Your ref: BE/151/11
Our Ref: AR15.11/DA

13th January 2012

Shripney Garden Caravan Park, Shripney Lane, Bognor Regis

We refer to your email of 6th January 2012 requesting amendments to the application for the extension to existing caravan park to provide 12 no. additional mobile homes, associated parking area, formation of access and construction of electrical intake housing (amendment to application BE/42/10).

SHRIPNEY GARDEN CARAVAN PARK, SHRIPNEY LANE, SHRIPNEY
Proposals 01 B
Nov 2011

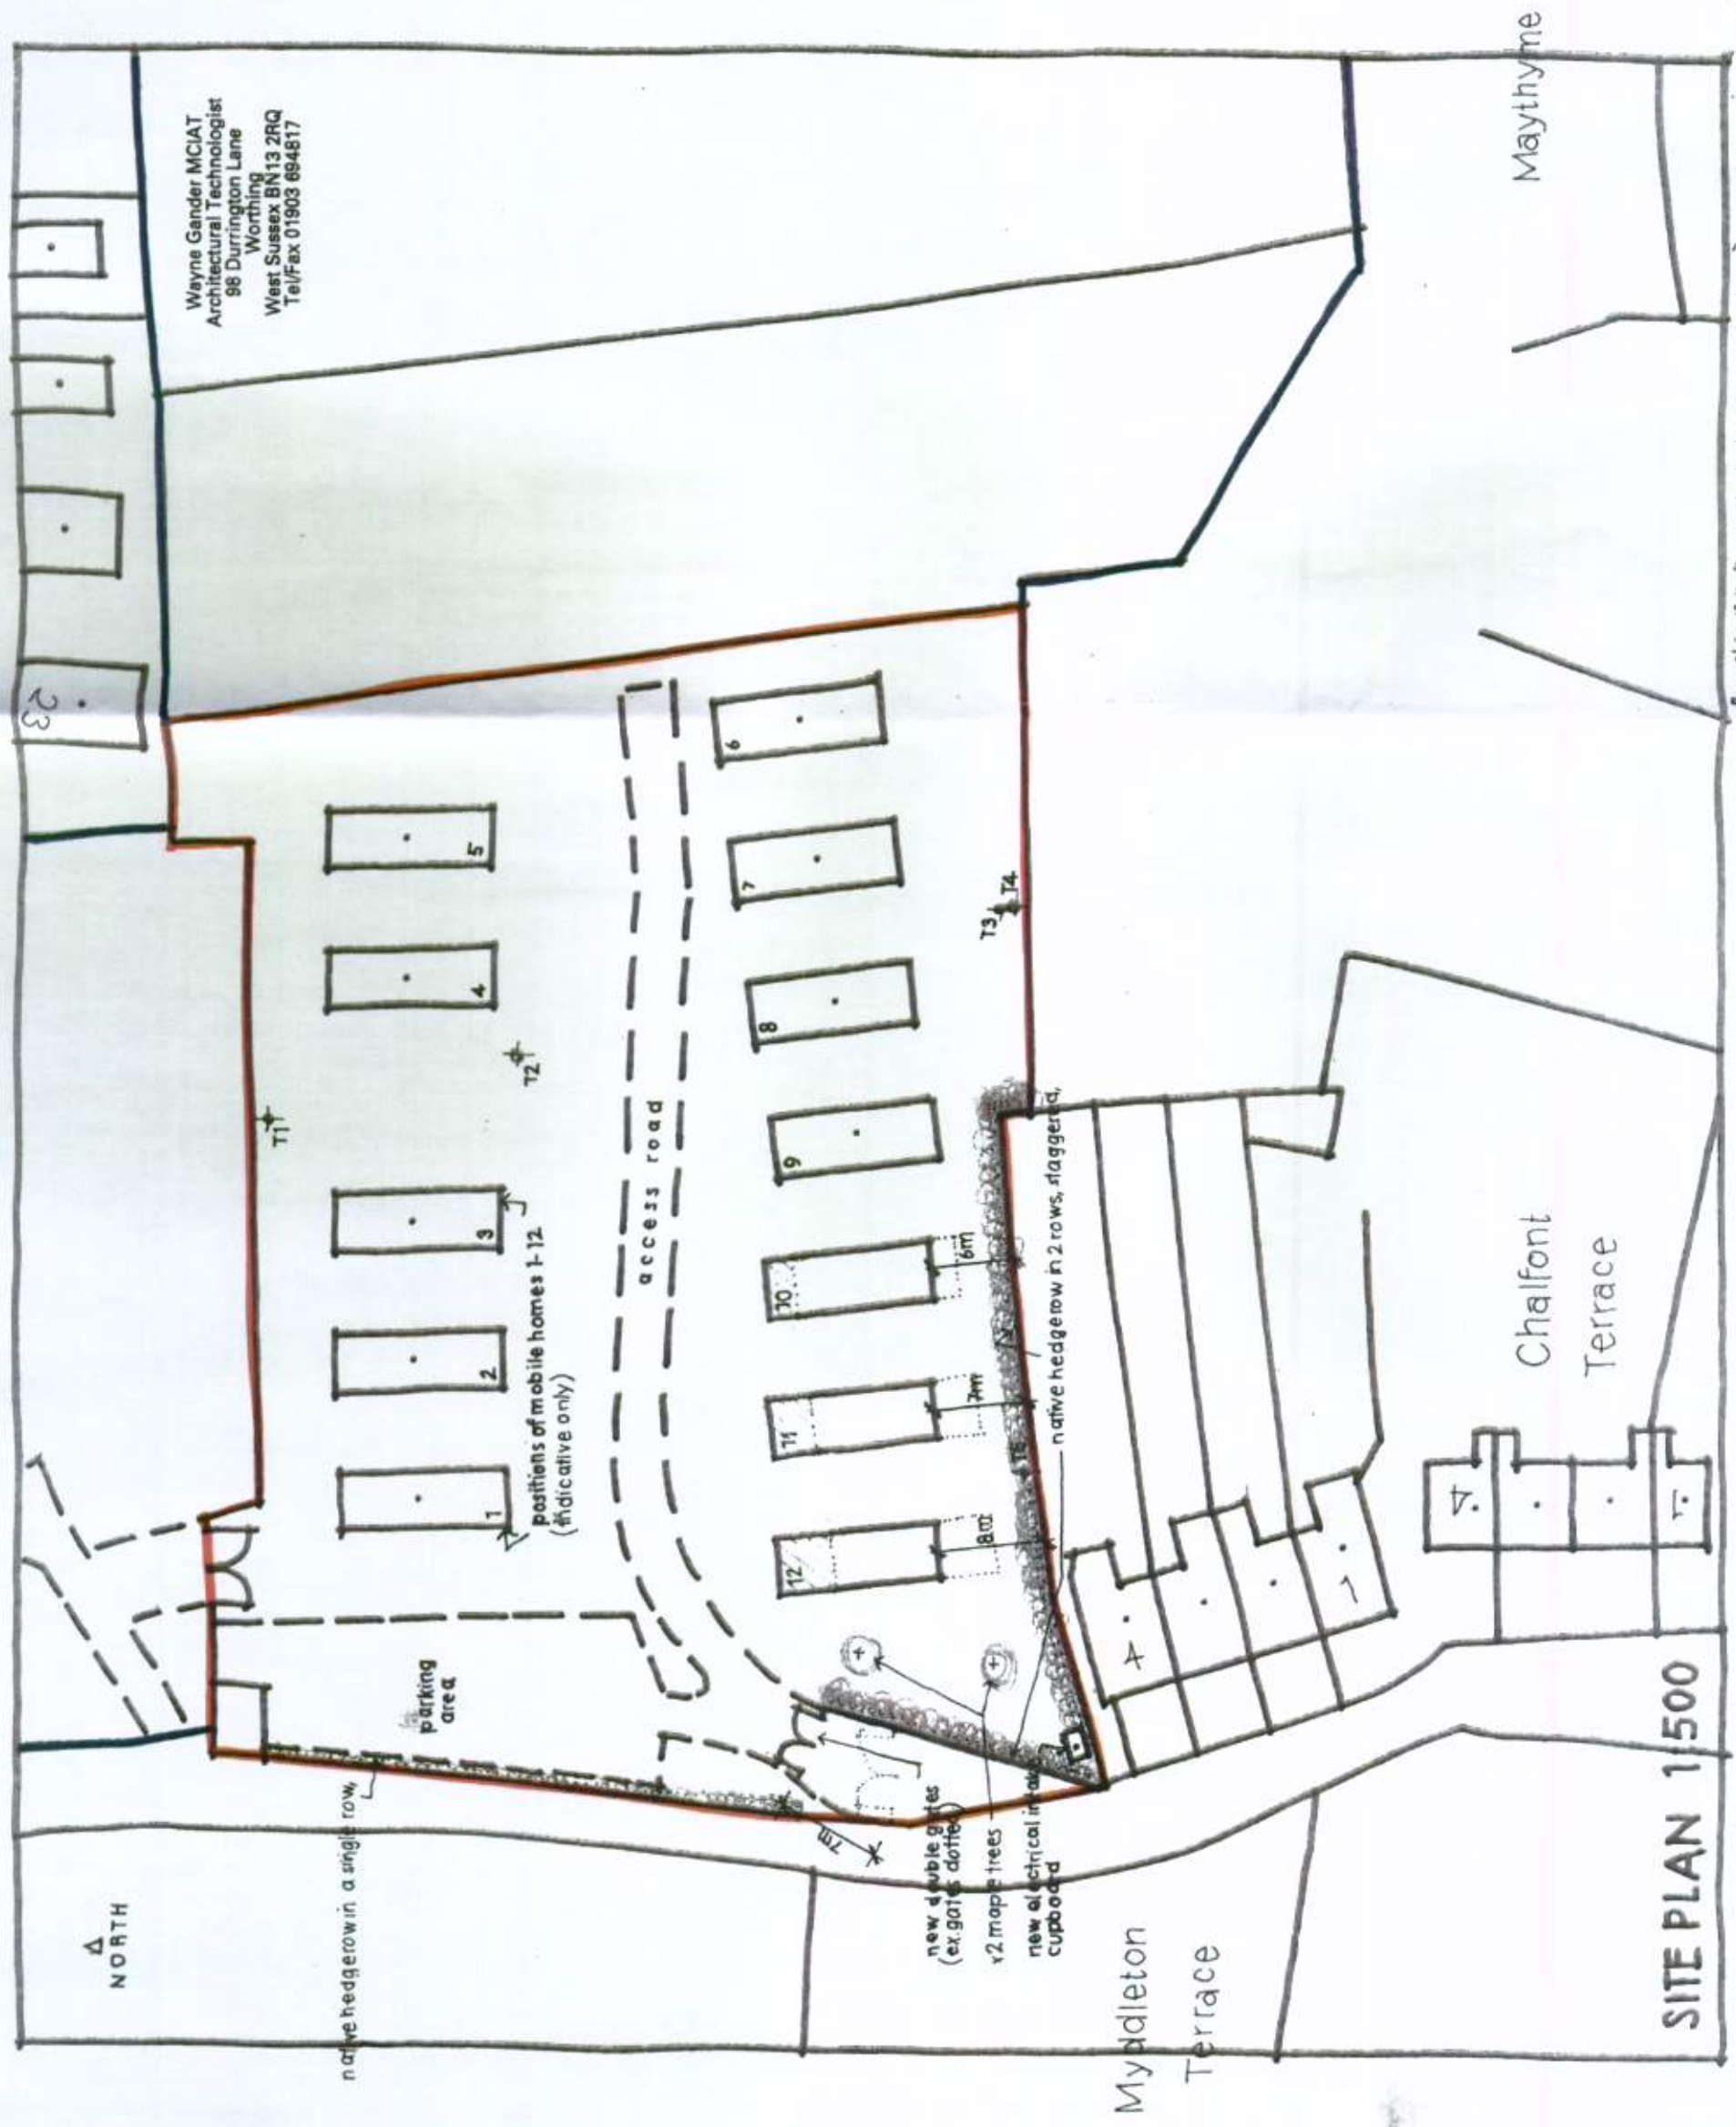
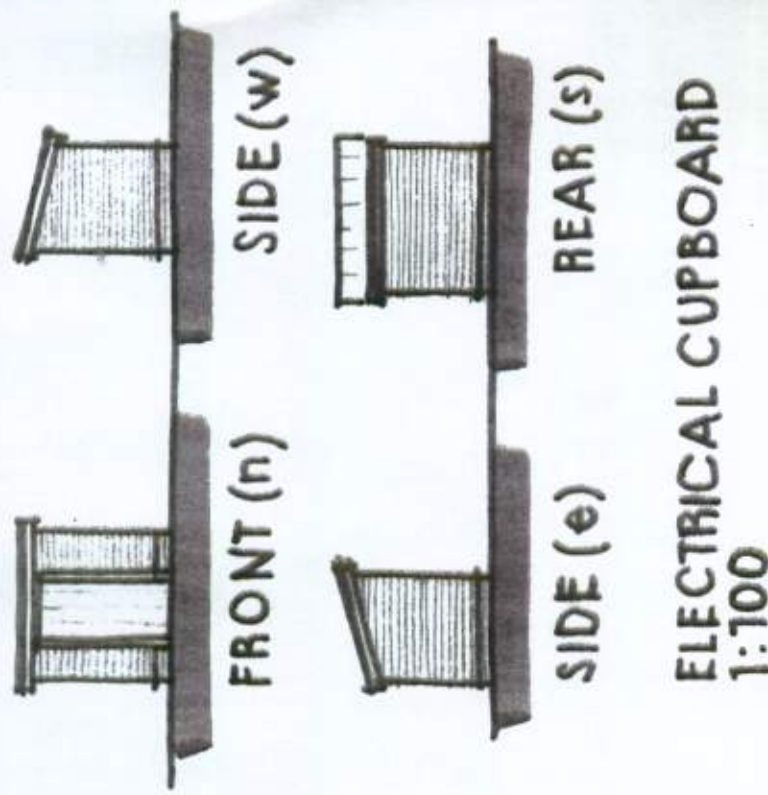
Firstly, you have requested a detailed landscaping scheme along the roadside and the boundary with Myddleton Terrace. We therefore enclose an amended site plan on which a native hedgerow is shown to be planted along these boundaries. The southern boundary from the electrical intake box to the rear boundary of Myddleton Terrace and the boundary along the access from the electrical intake box to the access gates will be planted with a double staggered row. The road frontage adjacent to the parking area and extending southwards to the access point will be planted with a single row due to space limitation. It is intended that the hedgerow will comprise:

Notwithstanding the above comments, our client clearly wants to resolve this matter and complete the development and therefore is willing to adjust the position of the first three bases (no.s 10, 11 and 12). It is therefore proposed that each base is reduced on its southern side and extended on its northern side towards the access road. The resulting

separation distance from the southern boundary will be as annotated on the plan and accords with the distances on the indicative approved plan. This, taken together with the proposed planting, will result in a layout comparable in terms of impact with the approved indicative plan.

Finally, with the regard to the issue of the setting back of the gates, we are unclear what this is trying to achieve. The gates are currently set back sufficiently to enable a car to wait off the highway whilst the gates are opened. Equally, on exiting the site vehicles will stop at the edge of the highway which will be unaffected by the relocation of the gates. We understand that the highway authority has no concerns with the current access arrangement. We therefore seek further clarification on this point but in the meantime have indicated what a setback of the gates would look like on the revised plan. This needs to be checked on site though as we don't believe seven metres which have been requested can be achieved before the entrance to the car park.

Crataegus monogyna (Hawthorn) 50%
Prunus spinosa (Blackthorn) 20%
Cornus sanguinea (Dogwood) 10%
Ligustrum vulgare (Wild Privet) 10%
Rhamnus frangula (Alder Buckthorn) 5%
Ilex aquifolium (Holly) 5%

The species will be planted in 2 staggered rows 300mm apart and each plant 500mm apart within the row.
